**DELEGATED DECISION FOR APPLICATION FOR CERTIFICATE OF
LAWFUL DEVELOPMENT**

Reference no.: 2021/CL/91586/E

Site: 17, Brook Meadows, Denby Dale, Huddersfield,
HD8 8GW

Description: Certificate of proposed lawfulness for proposed
conversion of garage/store to living accommodation

EXISTING & PROPOSED FLOOR PLANS & SPECIFICATION

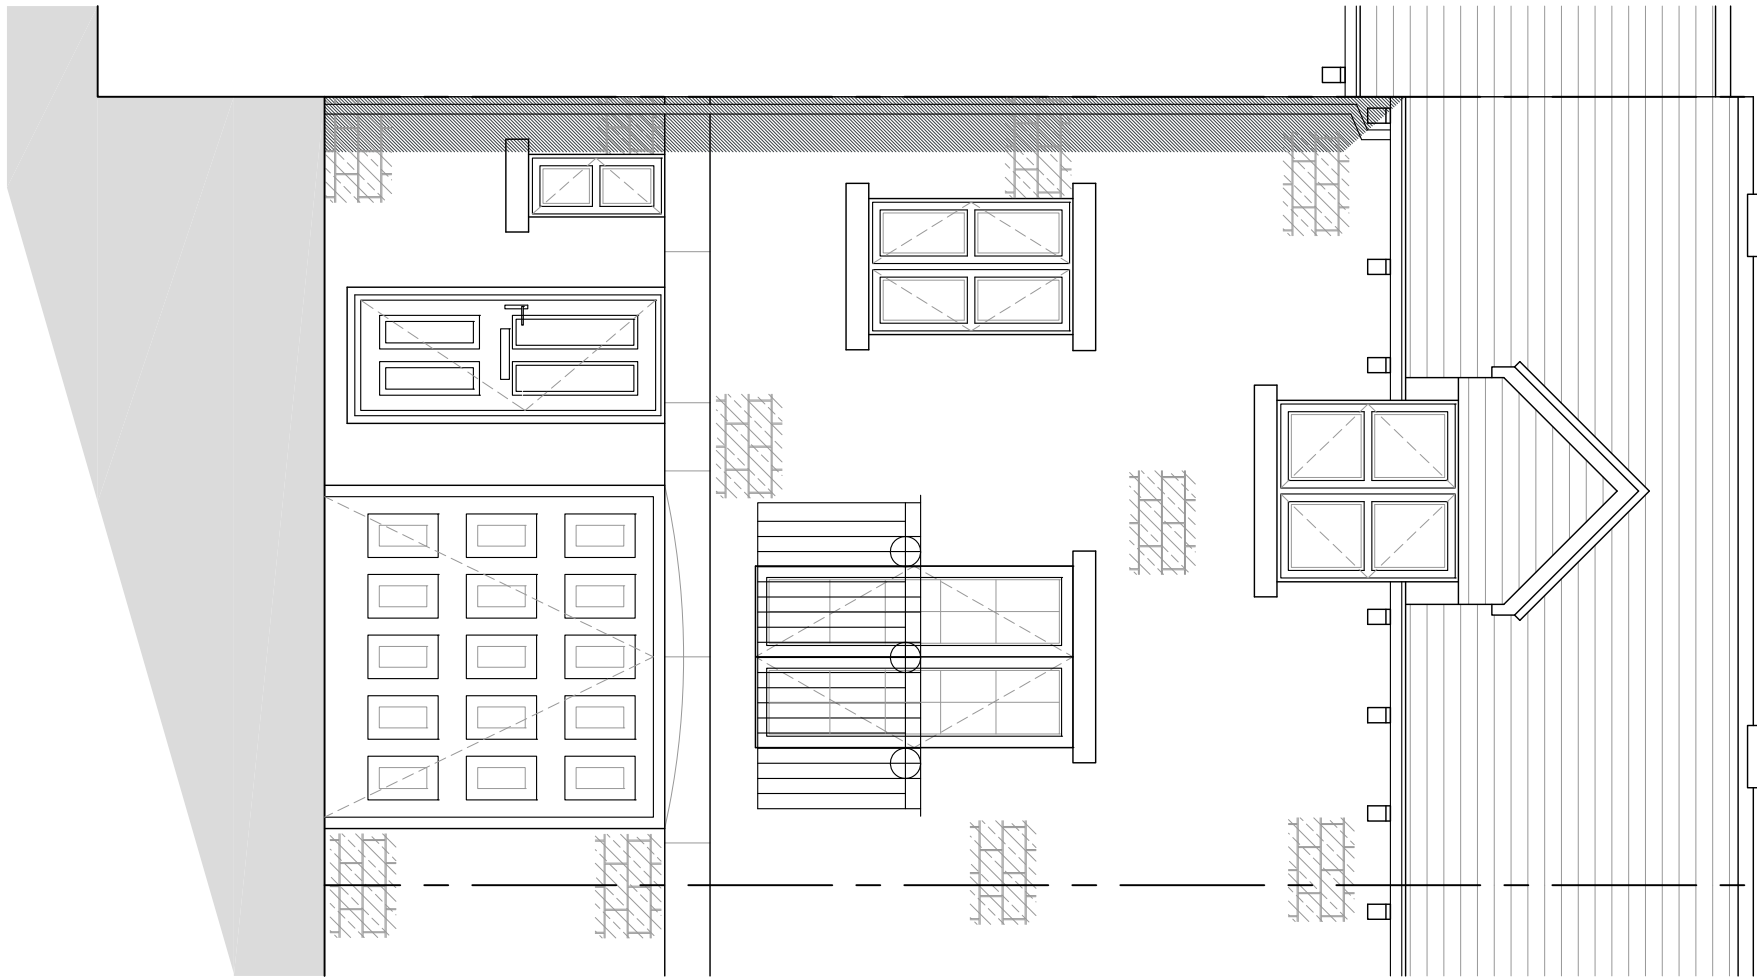
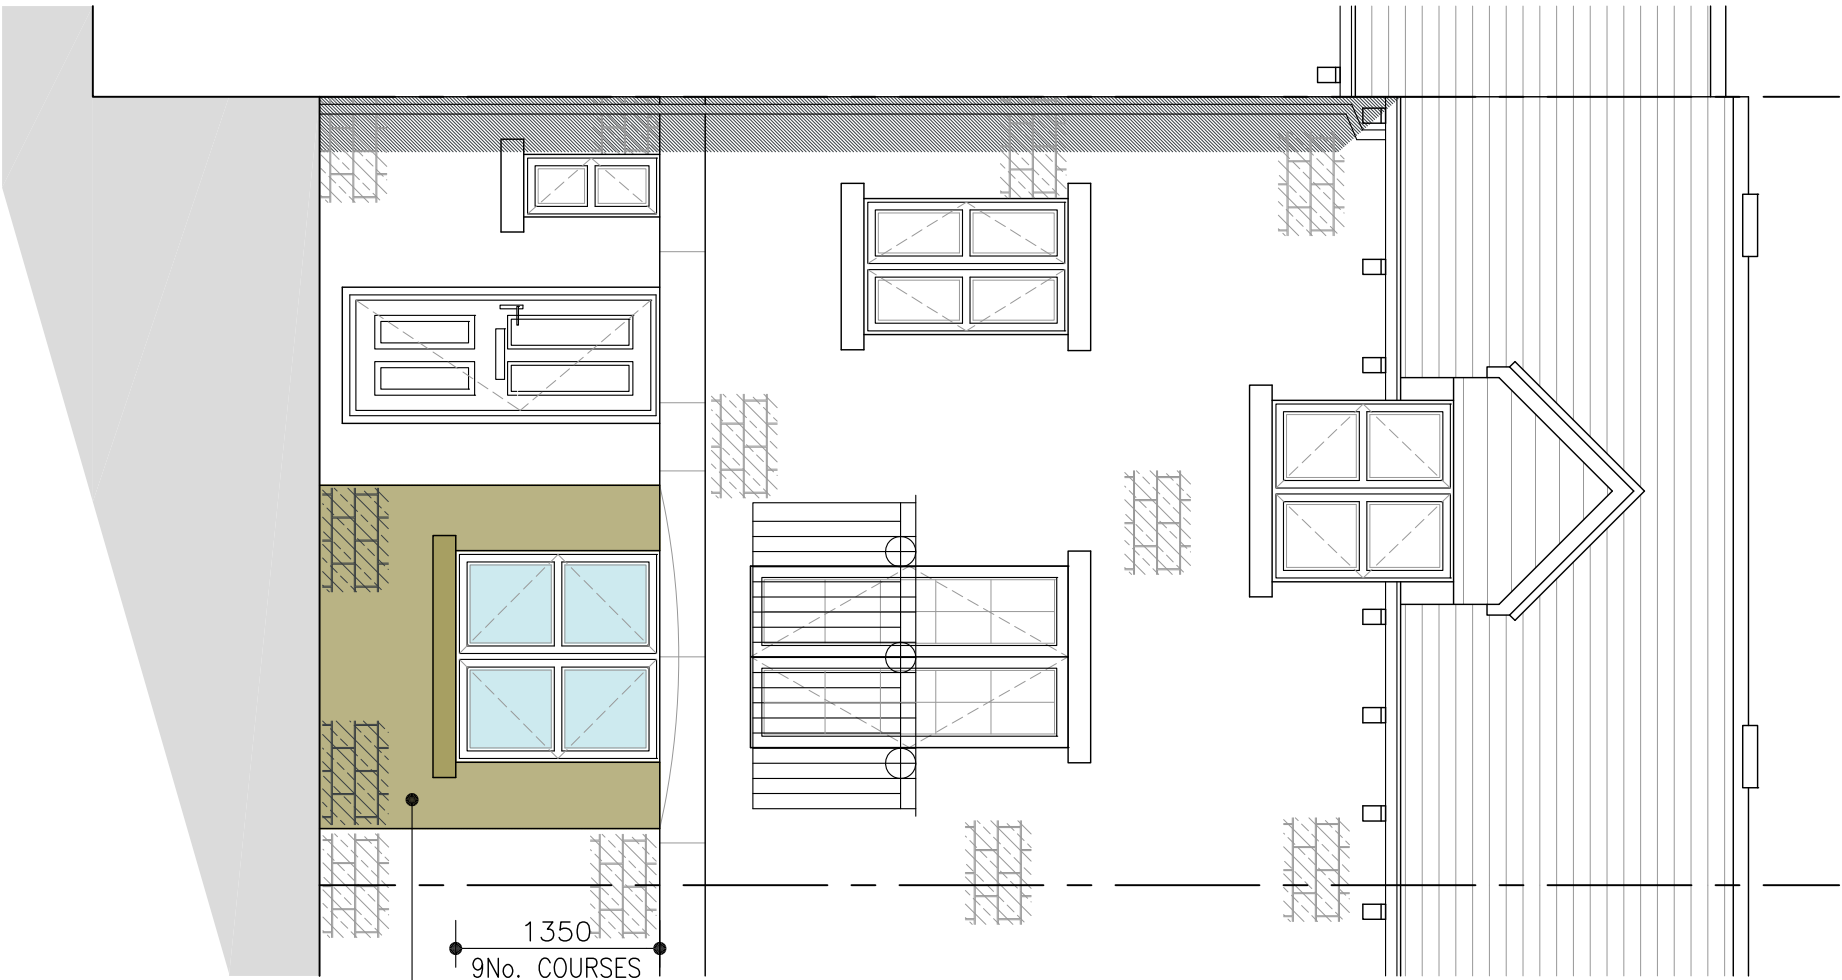
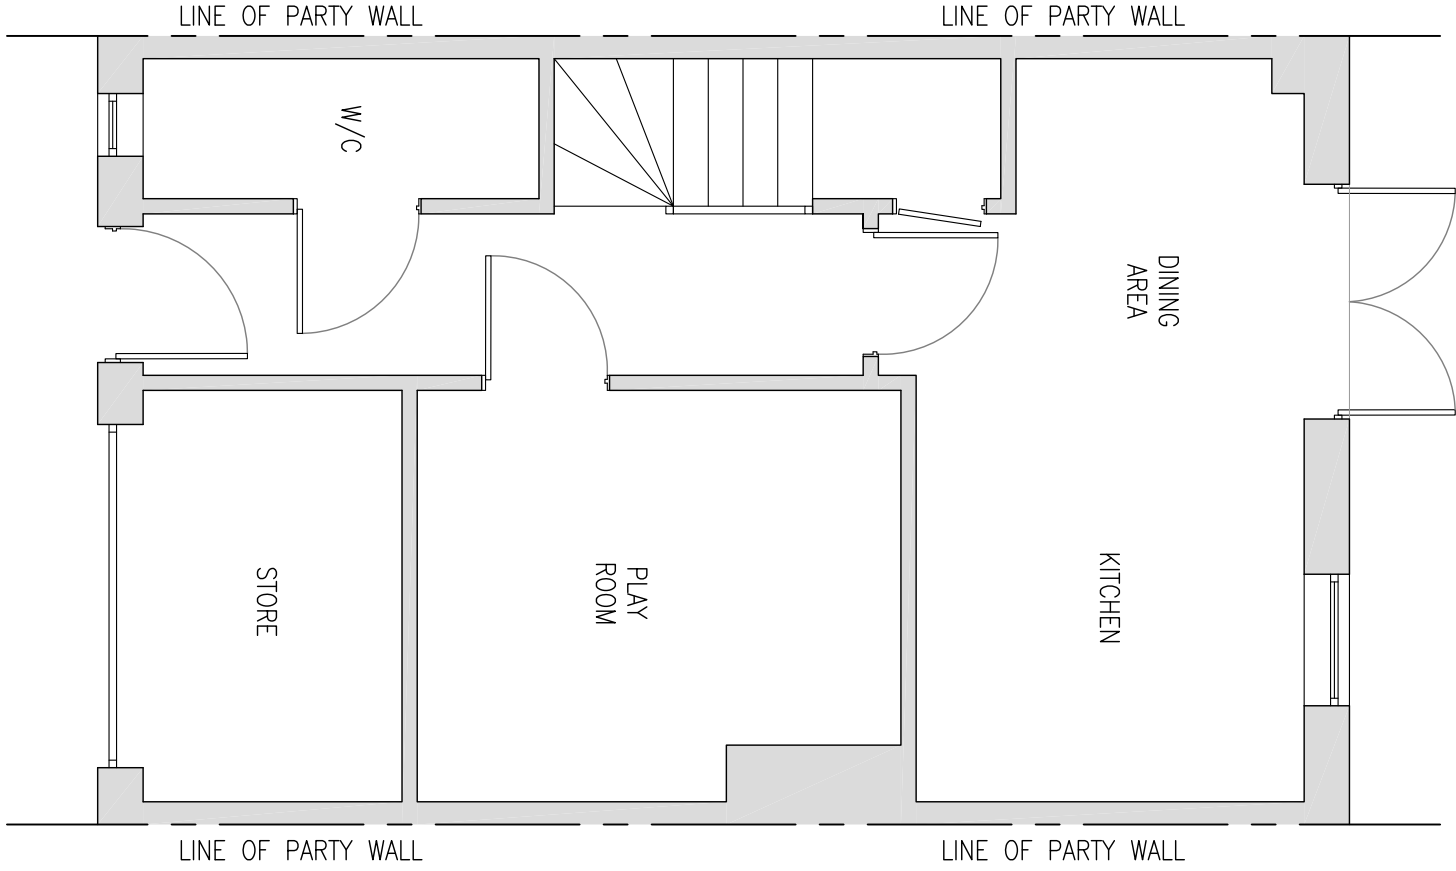
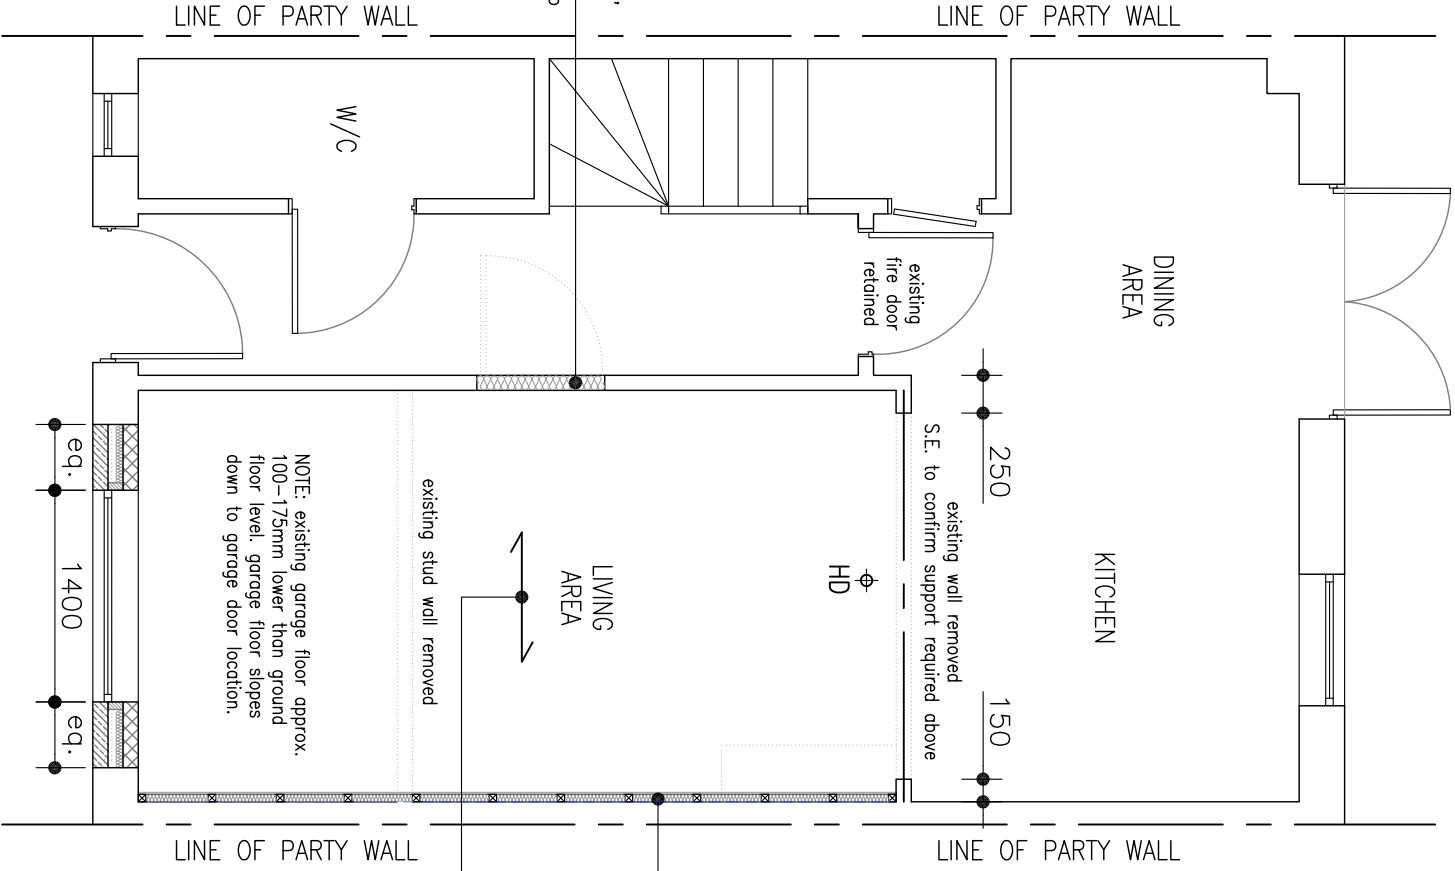
Permission is sought for a Certificate of Lawfulness for the proposed conversion of garage/store to living accommodation. The proposed alterations would accommodate a living area. The property would not be extended as part of the proposal. The existing garage door would be replaced with a window measuring approximately 1.4m wide x 1.4m high. The window would be uPVC to match the existing, and the wall would be clad in stone to match the existing.

Comment: *The proposal would not extend beyond the footprint of the original dwellinghouse.*

Comment: *Not applicable as no alterations in height would occur within the proposed alterations.*

Comment: *Not applicable as there would be no enlargement as part of this proposal.*

Comment: *Not applicable as the integral garage is located at the ground-floor level and therefore, no windows will be located at upper-floor level.*

The proposed development has been assessed against the relevant legislation, the Town and Country Planning (General Permitted Development) (England) Order 2015 (as amended), Schedule 2 Part 1, Class A and it has been deemed permitted development. As a result, it does not require planning permission and the lawful development certificate is therefore approved.
